# CITY OF ALBUQUERQUE

**Re: Employment Center PWTF Grading and Drainage Plan and Drainage Management Plan**

**Engineer's Stamp dated 8-17-09 (Q16/DA4001)**

SHEET TITLE:
**GRADING &
DRAINAGE PLAN**

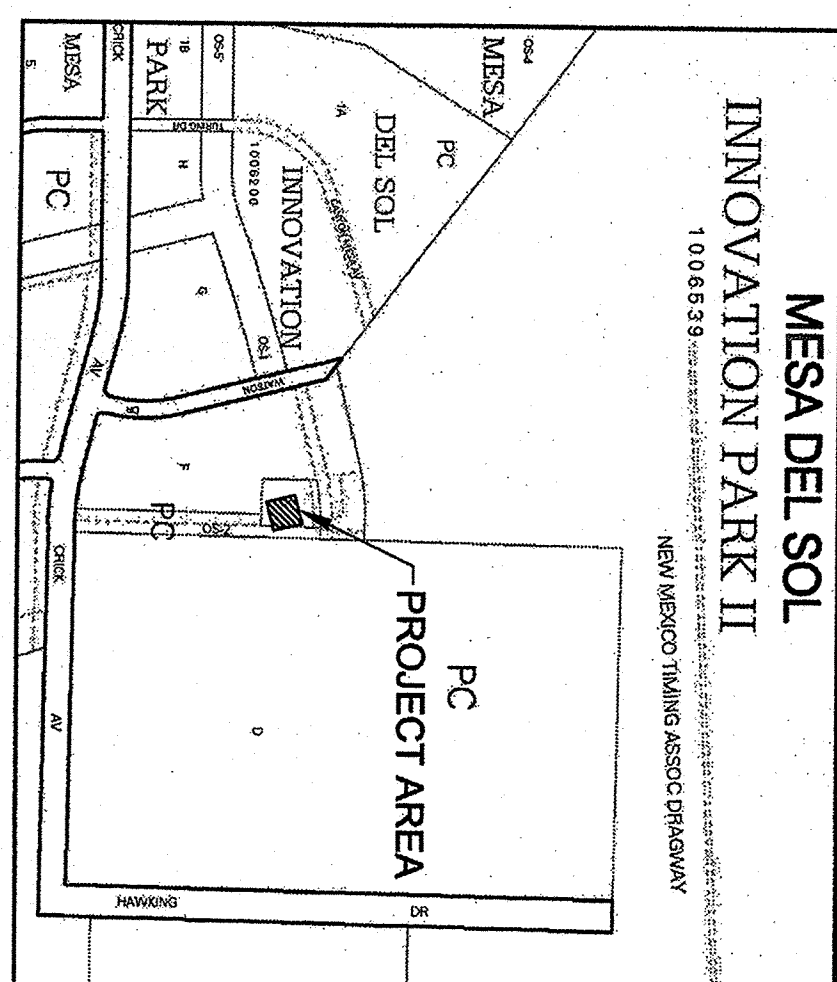
Concerning the Drainage Management Plan, it appears the WSE for the temporary pond is on Schott's property. A pond will be required to contain runoff from DA4 in DA4 with future development.
